**City of Portland, Maine - Building or Use Permit Application**  
 389 Congress Street, 04101 Tel: (207) 874-8703, Fax: (207) 874-8716

<b>Permit No:</b> 04-0166	<b>Issue Date:</b>	<b>CBL:</b> 066 F001001
------------------------------	--------------------	----------------------------

<b>Past Use:</b> Commercial	<b>Proposed Use:</b> Commercial / Install natural gas direct vent in attic.	<b>Permit Fee:</b> \$183.00	<b>Cost of Work:</b> \$0.00	<b>CEO District:</b> 3
<b>Proposed Project Description:</b> Install natural gas direct vent in attic		<b>FIRE DEPT:</b> <input type="checkbox"/> Approved <input type="checkbox"/> Denied	<b>INSPECTION:</b> Use Group: Type	
		Signature:	Signature:	
<b>PEDESTRIAN ACTIVITIES DISTRICT (P.A.D.)</b>				
Action: <input type="checkbox"/> Approved <input type="checkbox"/> Approved w/Condition <input type="checkbox"/> Denied				
Signature:		Date:

315 Park Ave
Second Floor Plan
1/4" = 1'-0"

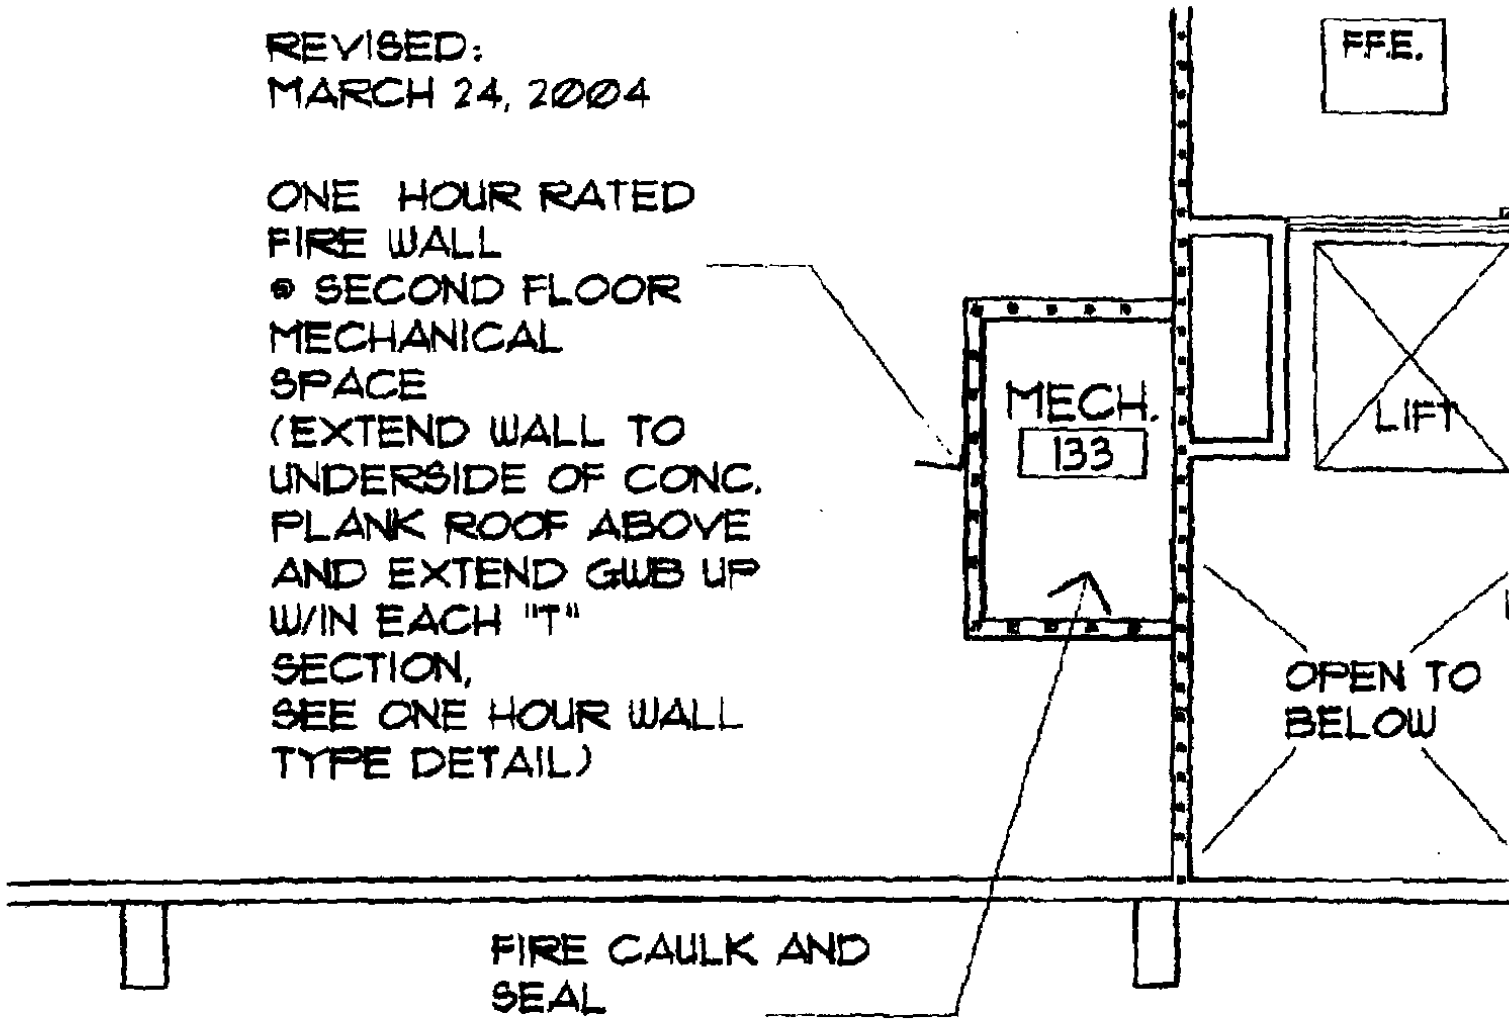
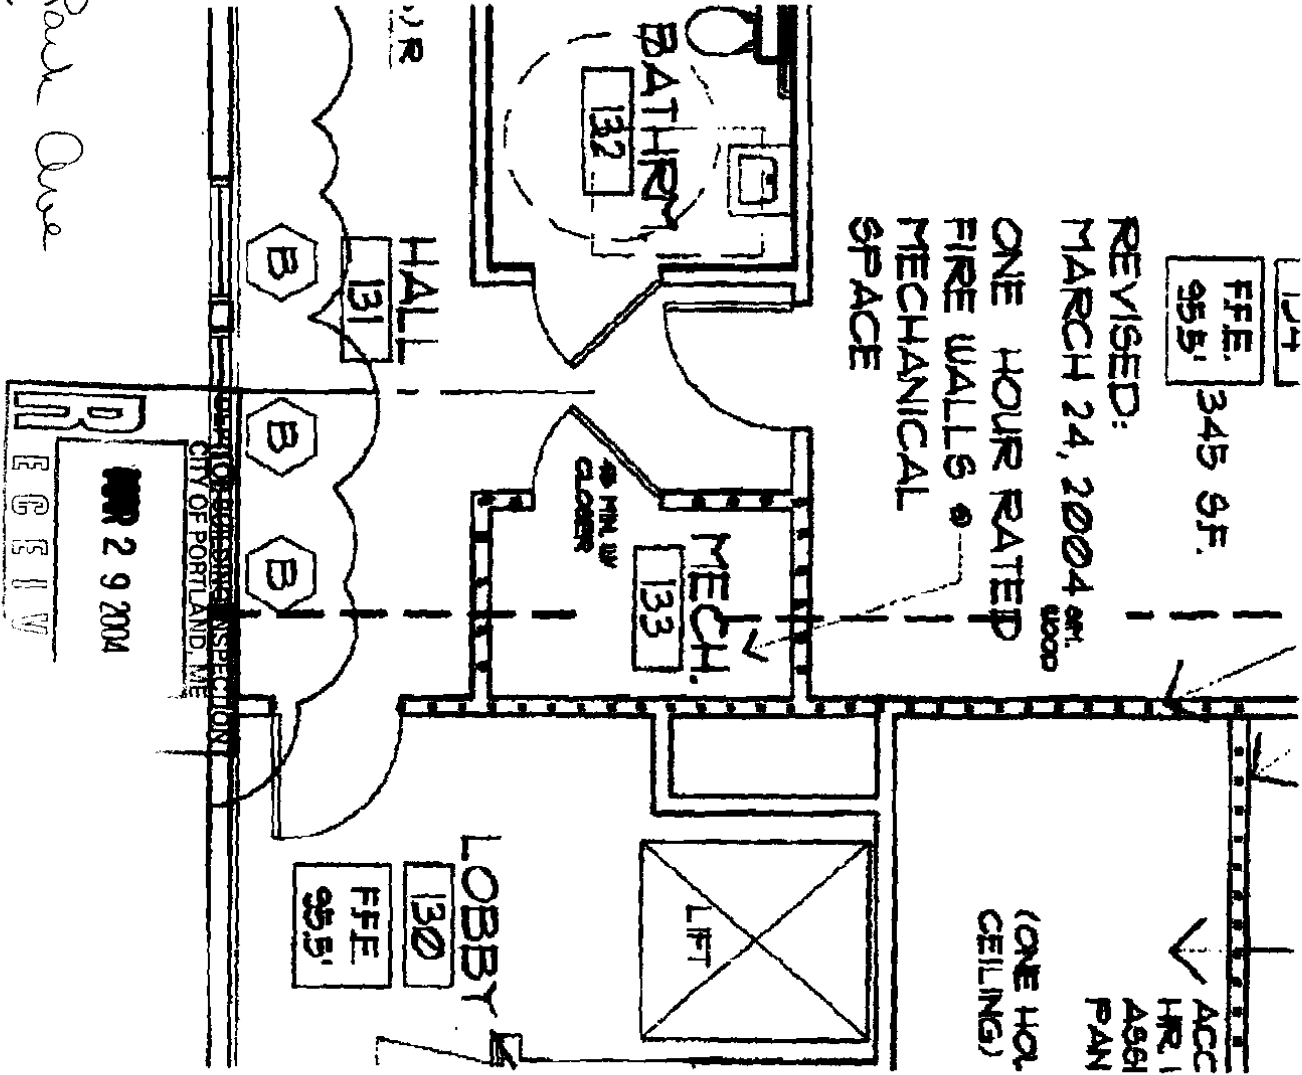
**Comments:**  
03/29/2004-gg: recieved structurals as requested. /gg  
03/09/2004-mjn: Need:  
Structurals, how is it being attached  
Fire Damper schedule (plan shows a duct penetration in the egress stairway..)
